FAO: Mr A Mangham
Planning Officer
Welwyn Hatfield Borough Council
The Campus
Welwyn Garden City
Herts AL8 6AE

RE: Notice of Objection
Application Reference: 6/2016/0391/VAR
Proposed Development at: 45 Northaw Road East, Cuffley Herts

Side Elevation Proposed

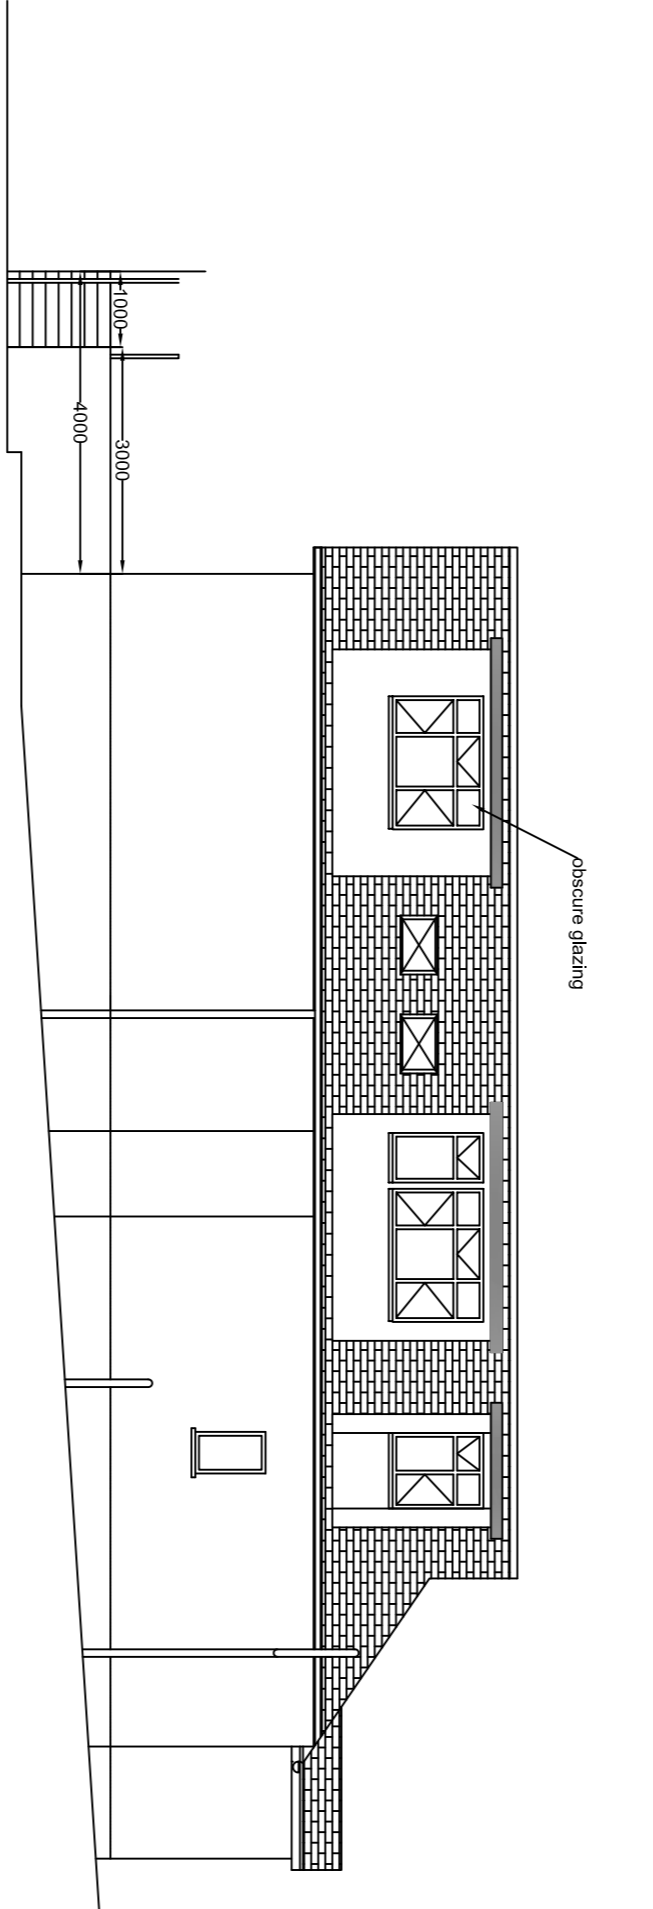
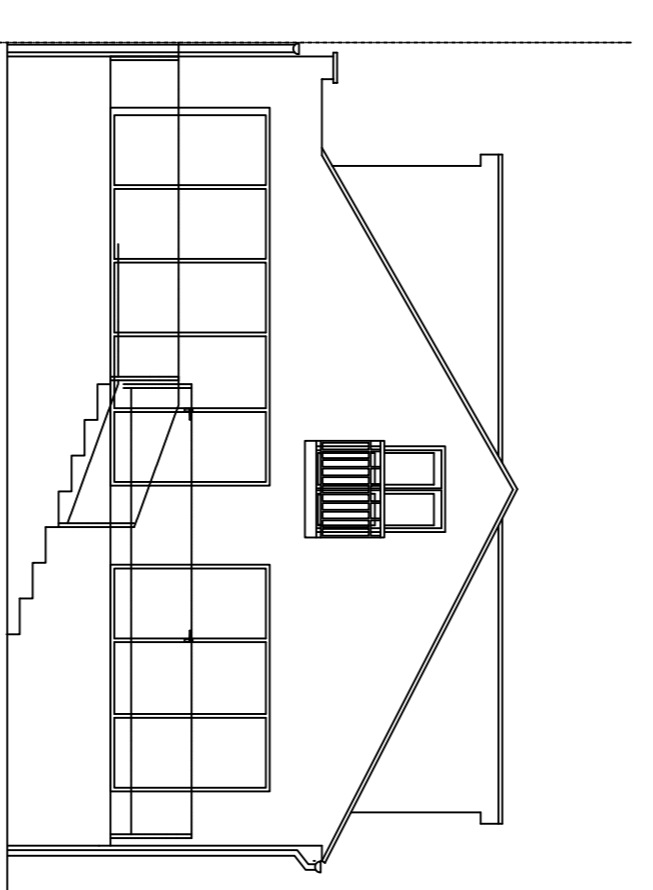
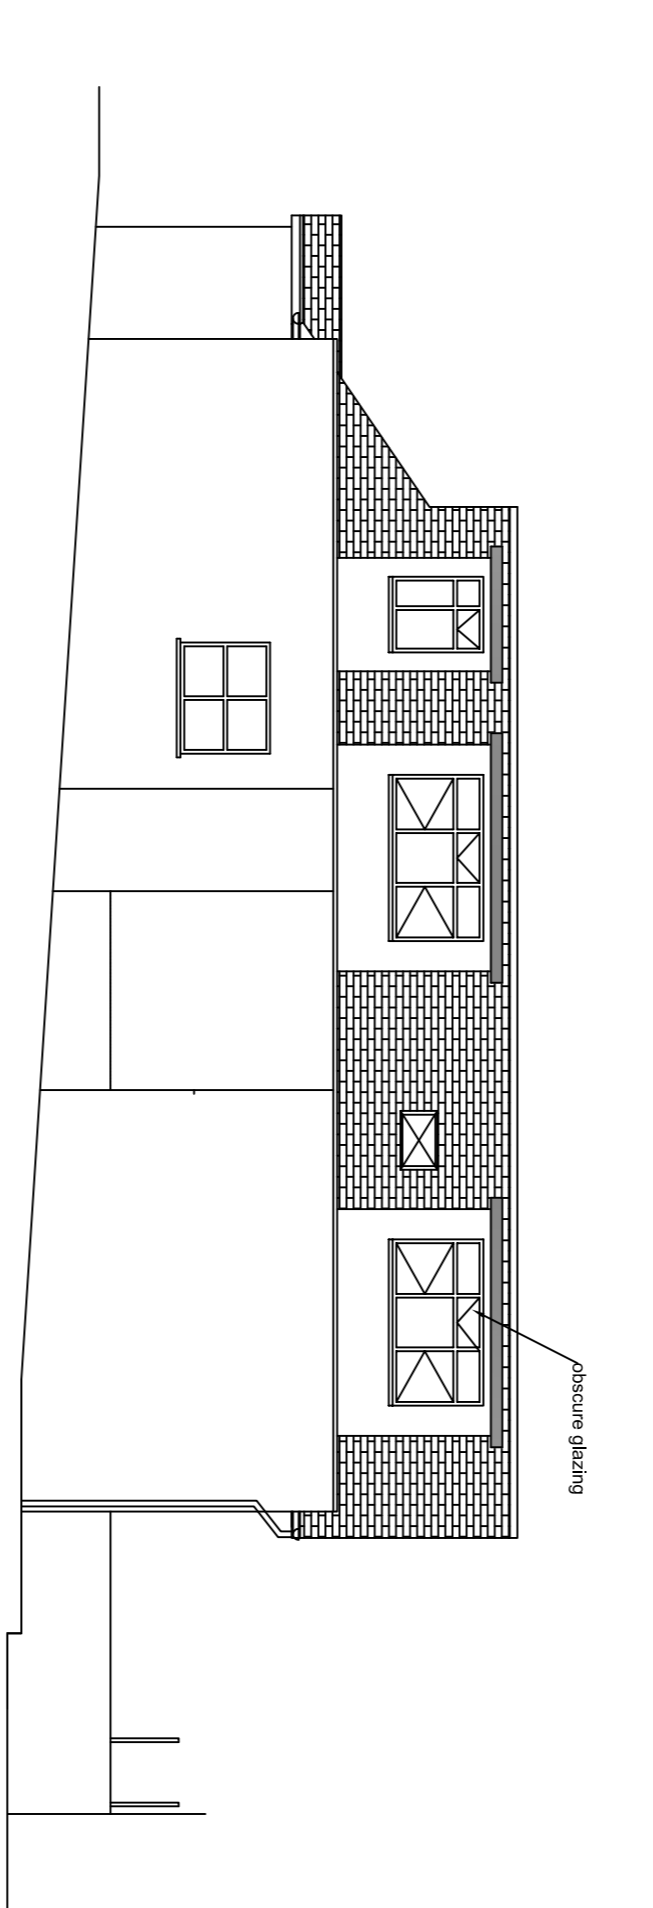
The Planning Drawing approved reference nor/plan/15 dated December 2015 shows on the side elevation proposed boundary wall at is maximum 3.5m high.

The resubmitted drawing referenced nor/plan/16 dated February 2016 shows the same elevation but 4m high.

Firstly as mentioned above it is actually 5m high and secondly it is higher than the original approved planning drawings.

This makes the property higher than the plans submitted for Planning and also means that the 3 dormers that look directly over our property are higher than they should be.

The parapet wall that has been built on the boundary wall adjacent to our property was not on the original plans and I assume has been built to negate a gutter, which would overhang our land. However this has made the boundary wall even higher than originally drawn and is not acceptable.

The ridge height of the roof has been raised without Planning Permission and breaks what has been established planning regulation in place for some time.

The height of all the ground floor walls has been raised without Planning Permission. Again it is standard practice that the ground floor wall height should not be altered and a loft extension does not give permission for this.

The size of the dormers are not in keeping with the surrounding area, the road or the neighbouring properties. They are oversized and overlook into properties on either side thereby causing them loss of privacy and intrusion

The dormers by their very size will look in to neighbouring properties reducing their right to privacy. Where dormer windows look in to another property, those dormers should be fitted with obscure glass.
